KITTITAS COUNTY FIRE MARSHAL'S OFFICE

Re: Saunders (BL-14-00011)

After conducting a review of the recent changes to the above named project, I have the following comments:

# EXHIBIT

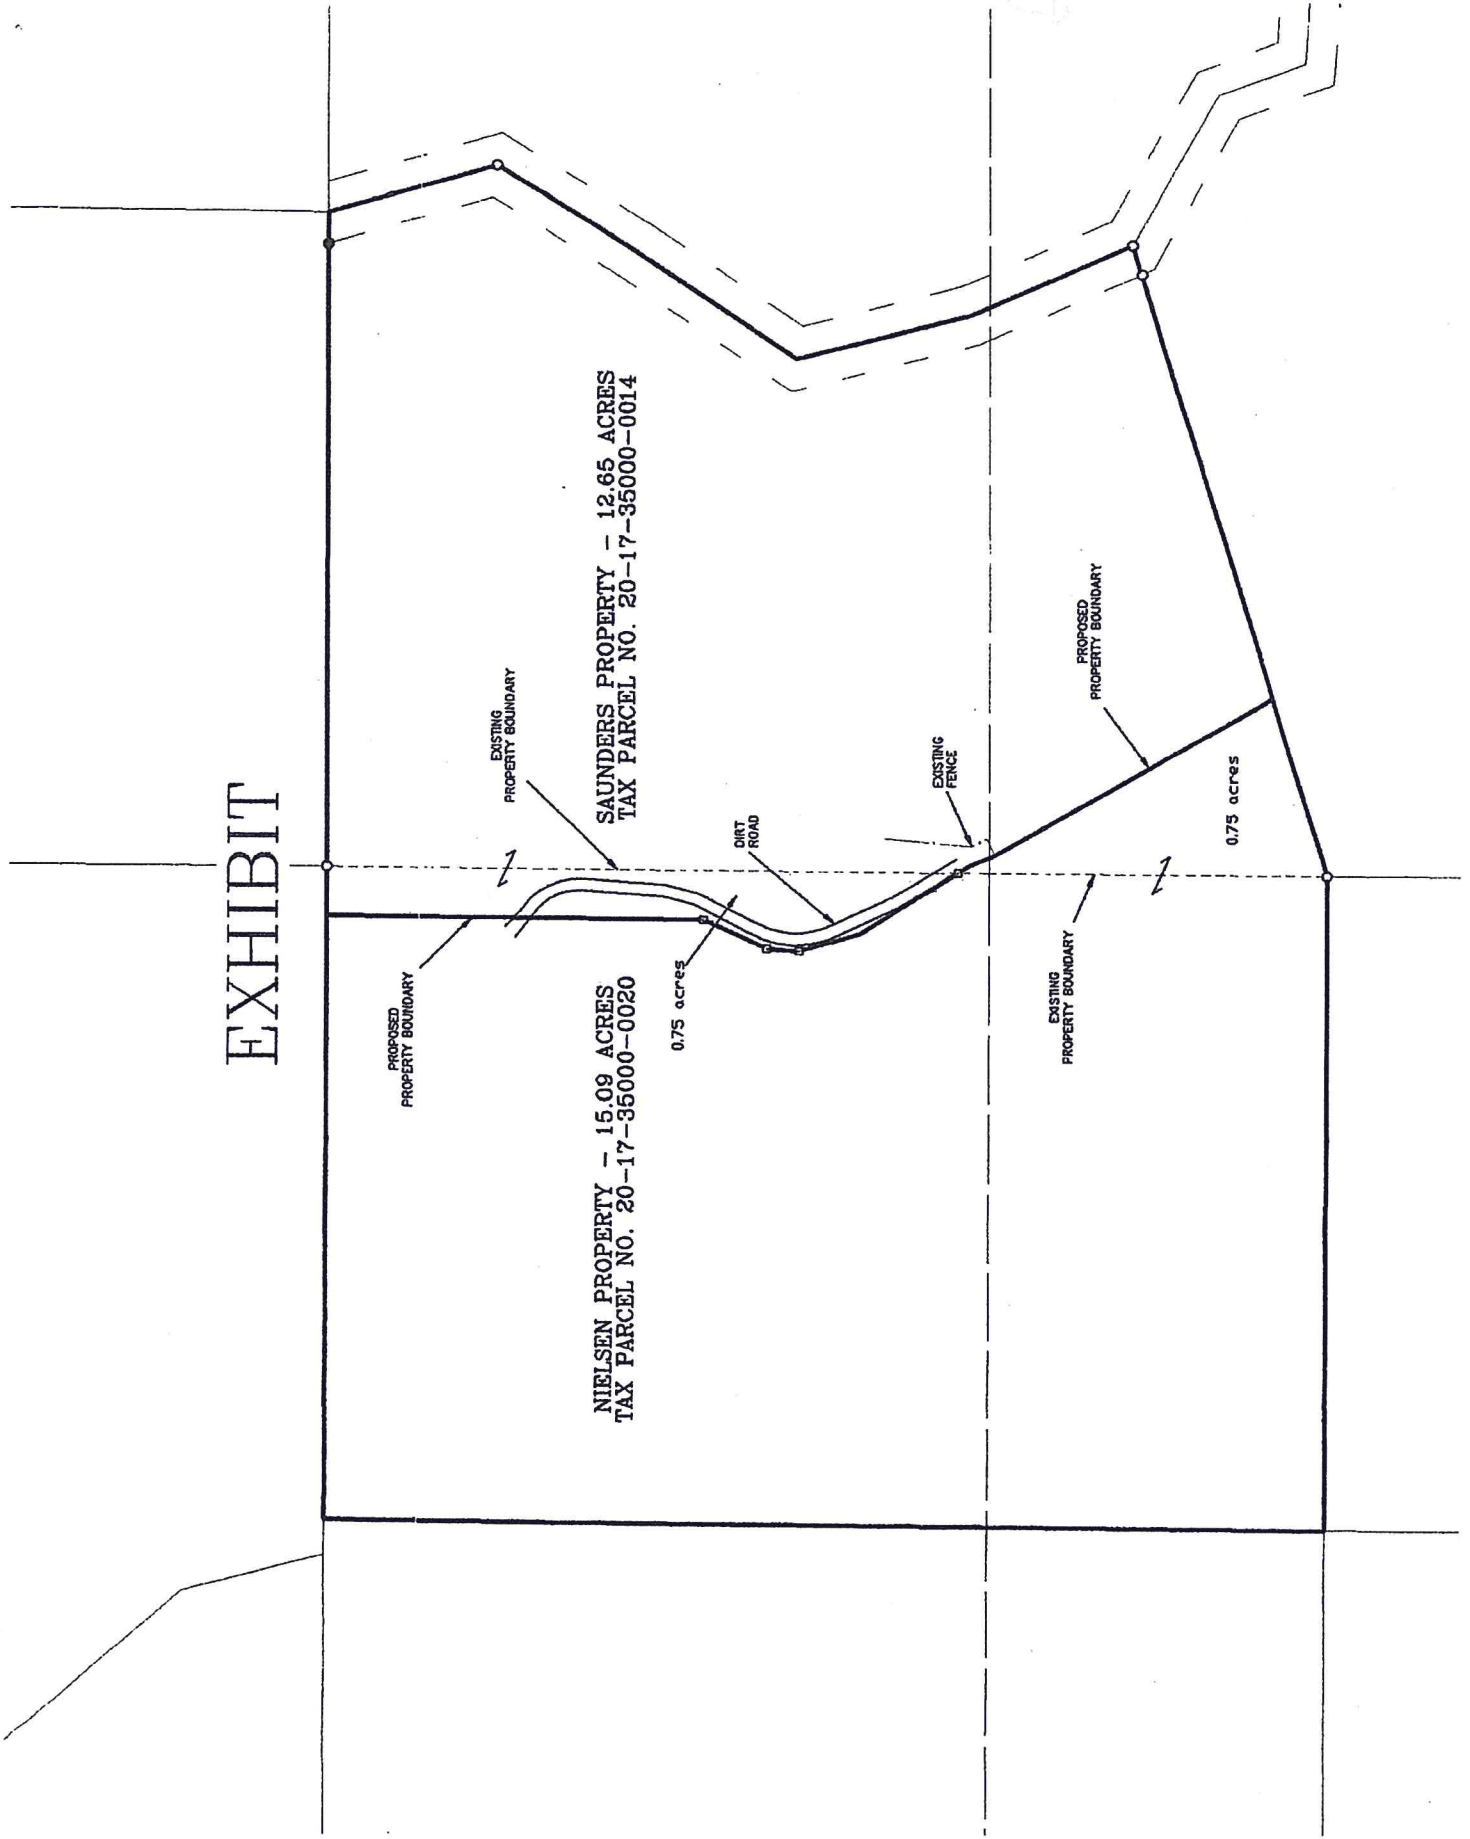
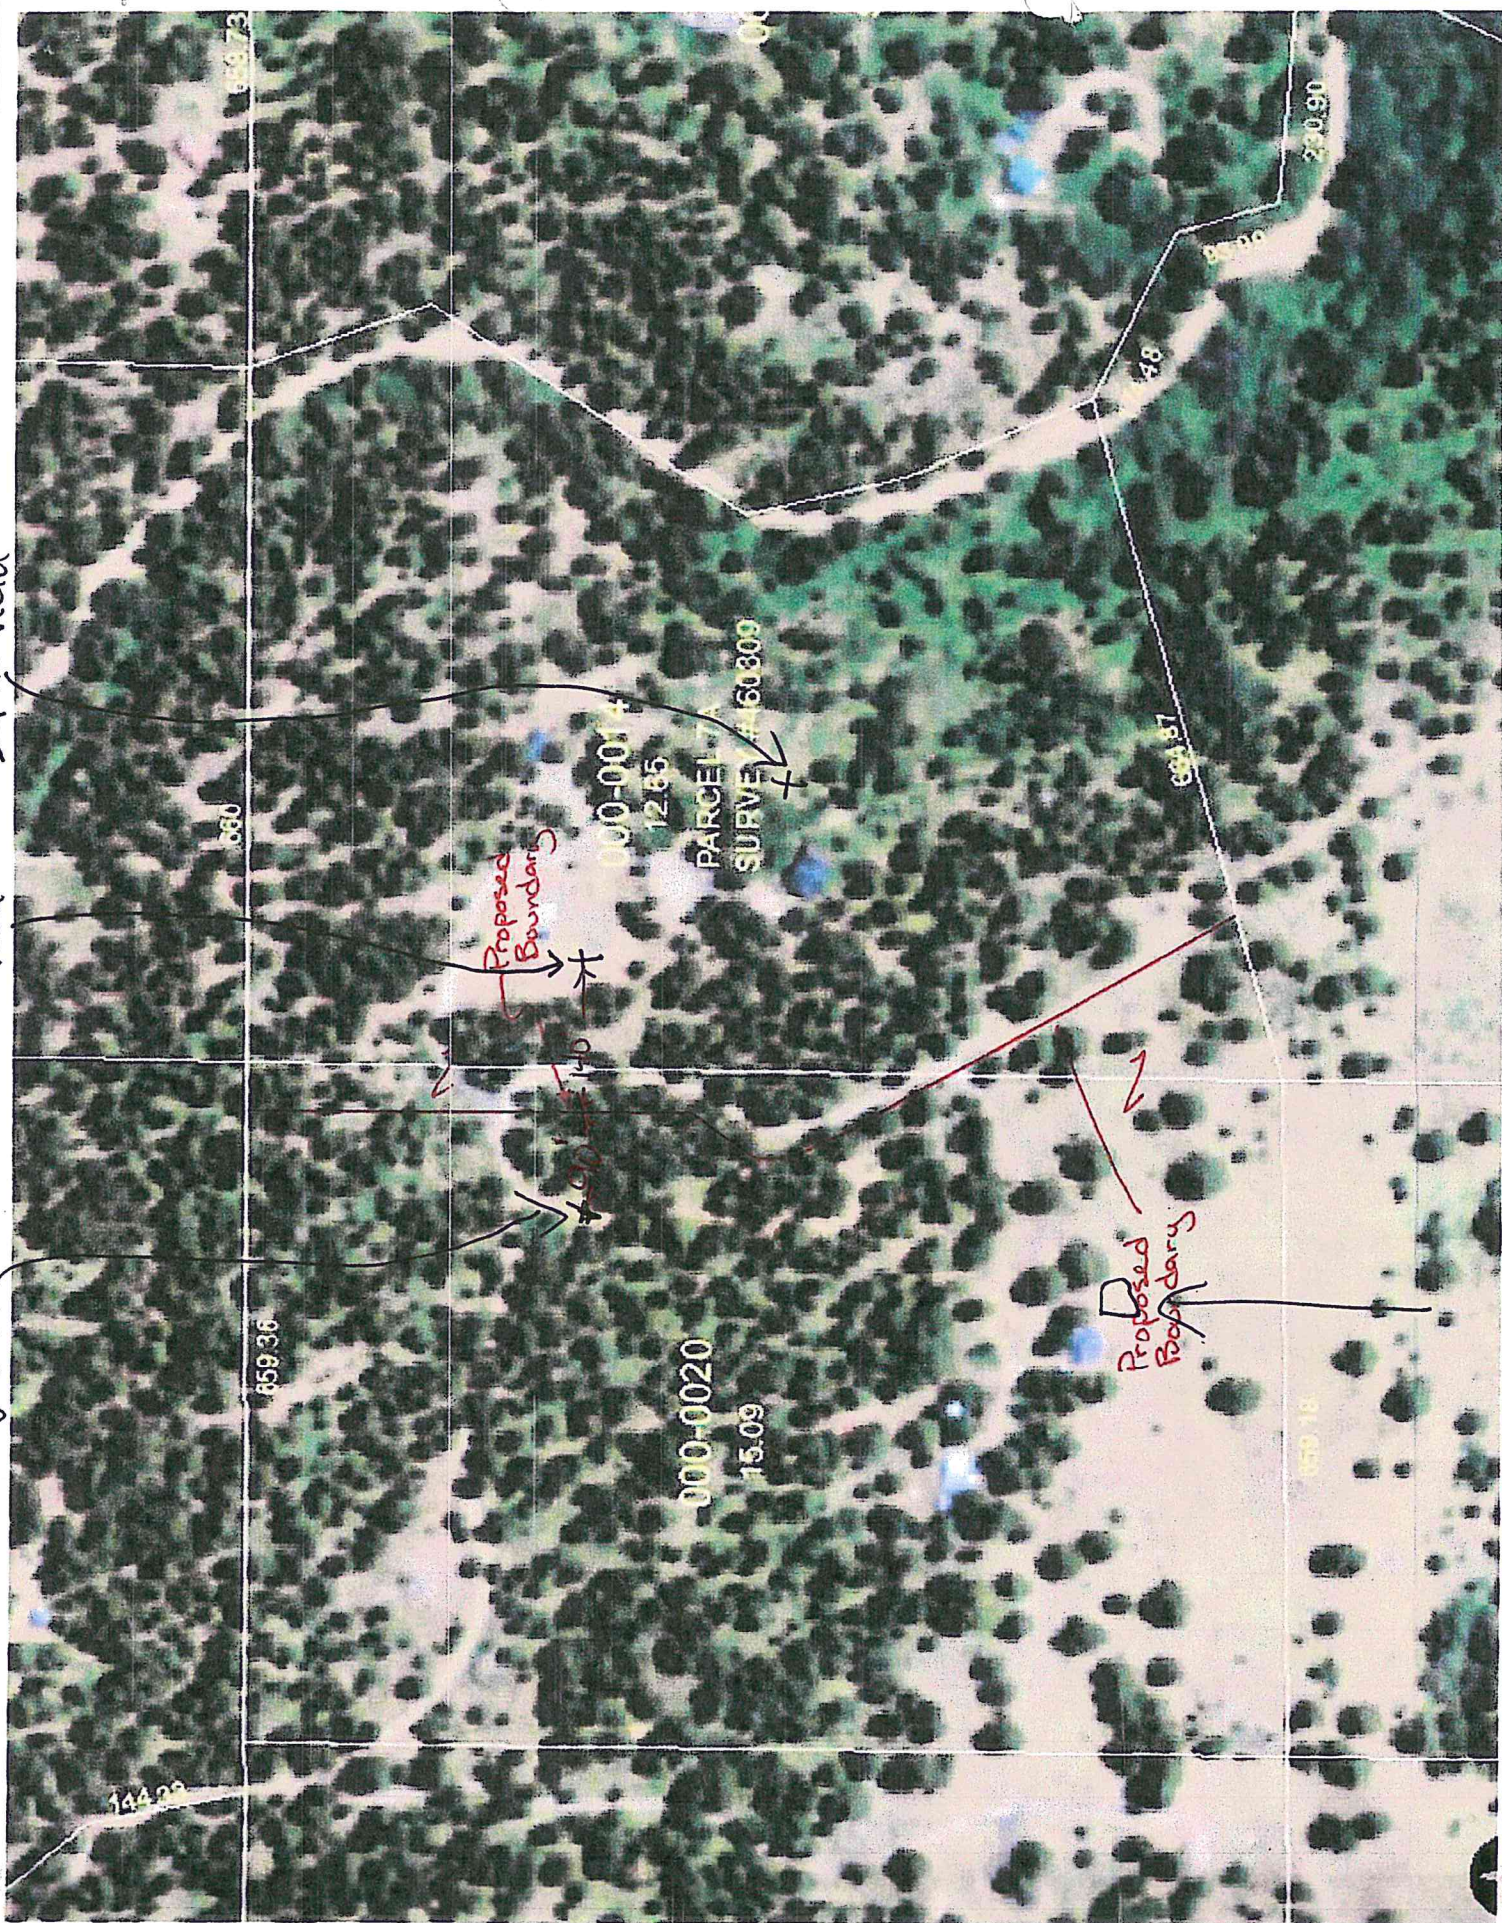
- Ensure that boundary line adjustments do not infringe upon existing structures, to include propane tanks, etc.
- Ensure adequate access for fire apparatus. Any driveways or access points created based off the new lot configurations shall comply with Kittitas County Code 20.02.030.
- All future development must comply with the International Fire Code.
